**Boyle Engineering Corporation**

February 7, 1983

RE: REGINA HALL  
DRAINAGE PLAN K15-D-18  
S01-118-18

REGINA HALL DRAINAGE PLAN

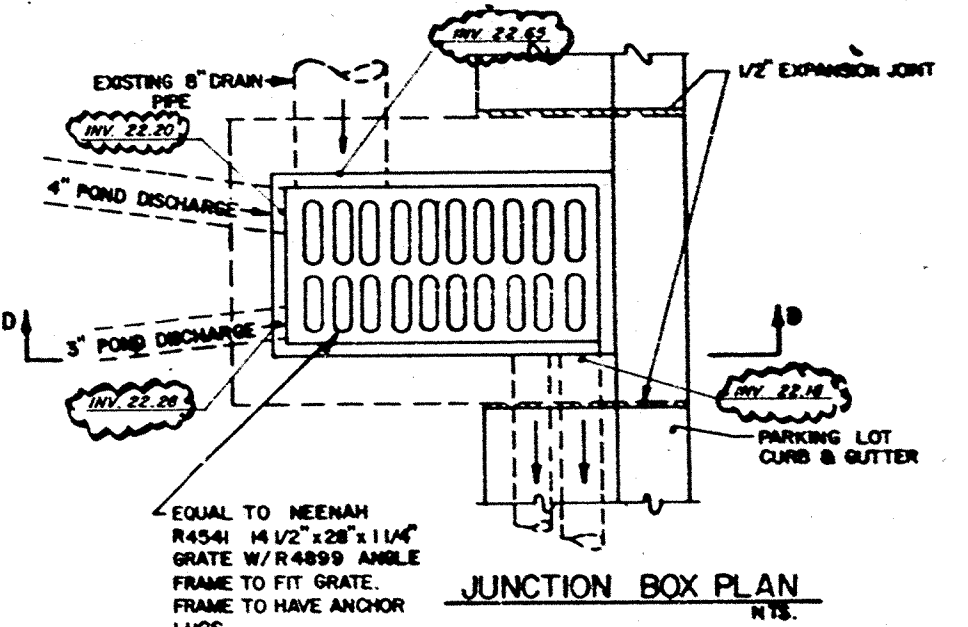
1. Several options for draining area 1 were investigated. However, since most of the Area 1 will be irrigated, draining this area to the street will result in nuisance waters being drained on to the pavement. Therefore, as we discussed by telephone it is now proposed to grade the area to collect nuisance water at three locations as shown on the plans.

SECTION E-E

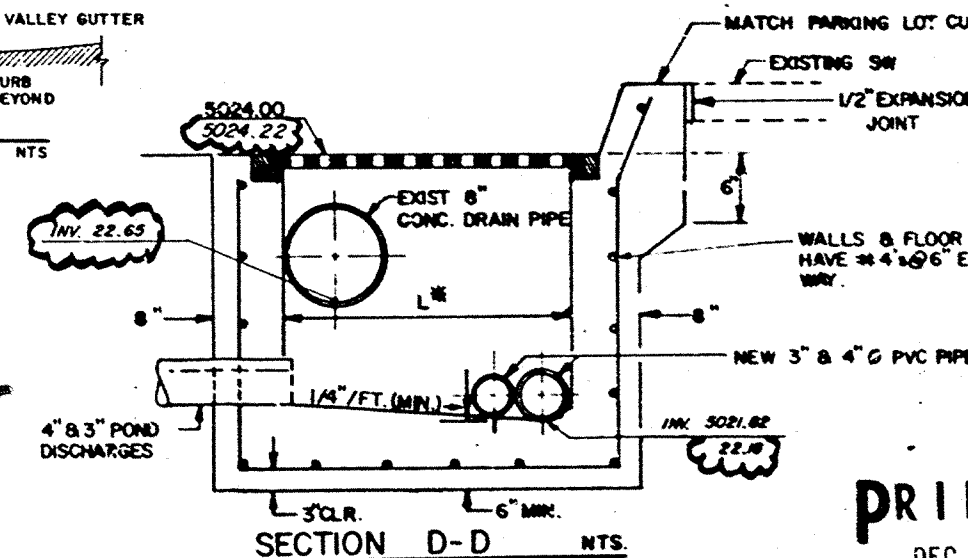
2. Irrigation runoff will be retained by three depressions described above.
3. Elevations have been added to section E-E. The high point in the driveway is 0.64 feet above the flow line on Elm Street. Then it drops 3 inches on the parking lot side. This does not meet the criterion that the drivepad at the property line should be one foot above street flow line. However, since the flow in Elm Street begins at Grand Avenue less than 120 feet north, it is very doubtful that the flow depth would be significant as it passes the driveway.

4. The 103 LF of pipe connecting the 2 small ponds has been eliminated.
5. Elevations have been shown at the drivepad and the curb returns on the inside of the parking lot. Elevations have also been shown on section E-E as stated in 3 above.
